June 12, 2007

RE: Final Site Inspection, (Project # 2006-0087), (CBL 382A D 021001)

Recently I visited the property at 539 Auburn Street, and conducted a site inspection for a Final Certificate of Occupancy. During my inspection it was observed that several site improvements were incomplete. Please be advised that your Temporary Certificate of Occupancy expires on June 15, 2007. The following items must be completed **prior** to the issuance of a Final Certificate of Occupancy (as outlined and agreed to in the conditions of approval relating to you building permit).

**GRADING PLAN**  
OF:  
**LOT 1 AUBURN ESTATES**  
LONGVIEW DRIVE  
PORTLAND, MAINE  
FOR:  
**BRUSH AND HAMMER INC.**

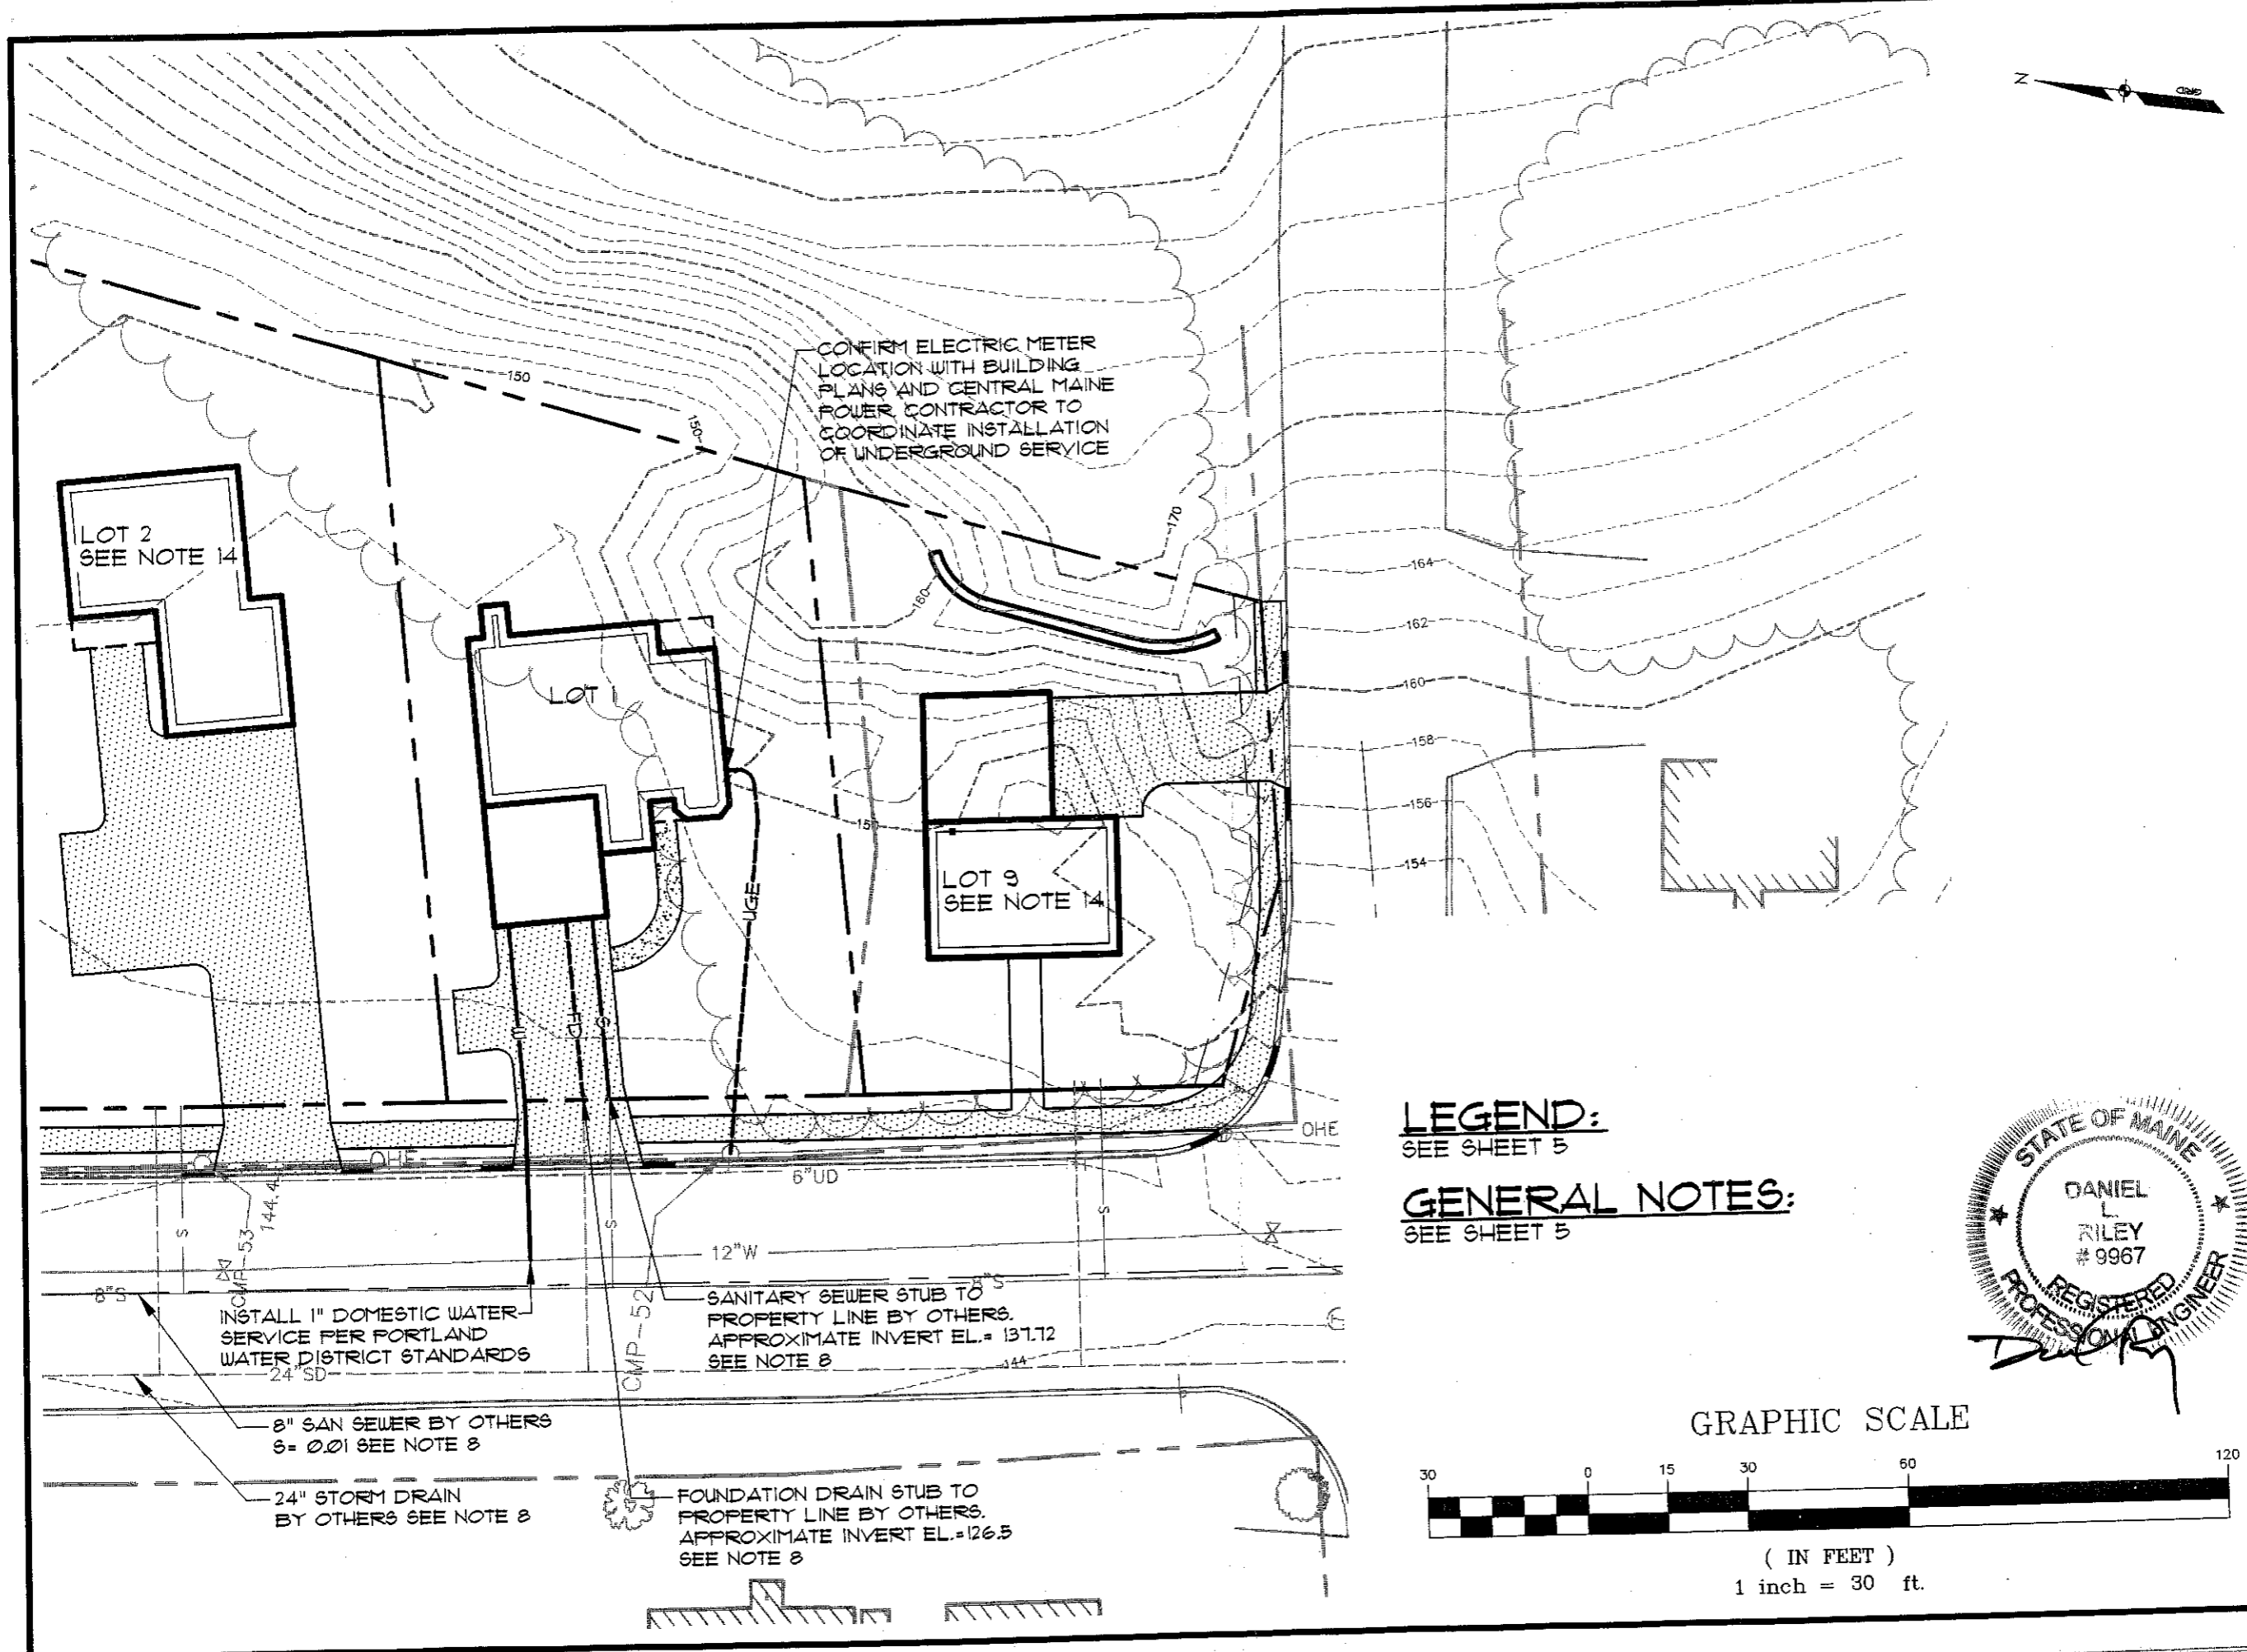
1. Final grading per the approved site plan; the grade along both sides and the front of your house appears to be pitched toward the house causing water to drain toward the foundation. Per the approved site plan, the grade should be pitched away from the foundation toward the street,
2. Loaming and seeding of all disturbed areas,
3. Two (2) City of Portland approved species and size trees must be planted on your street frontage. The trees must be a minimum 2 to 2 ½ caliper in size.
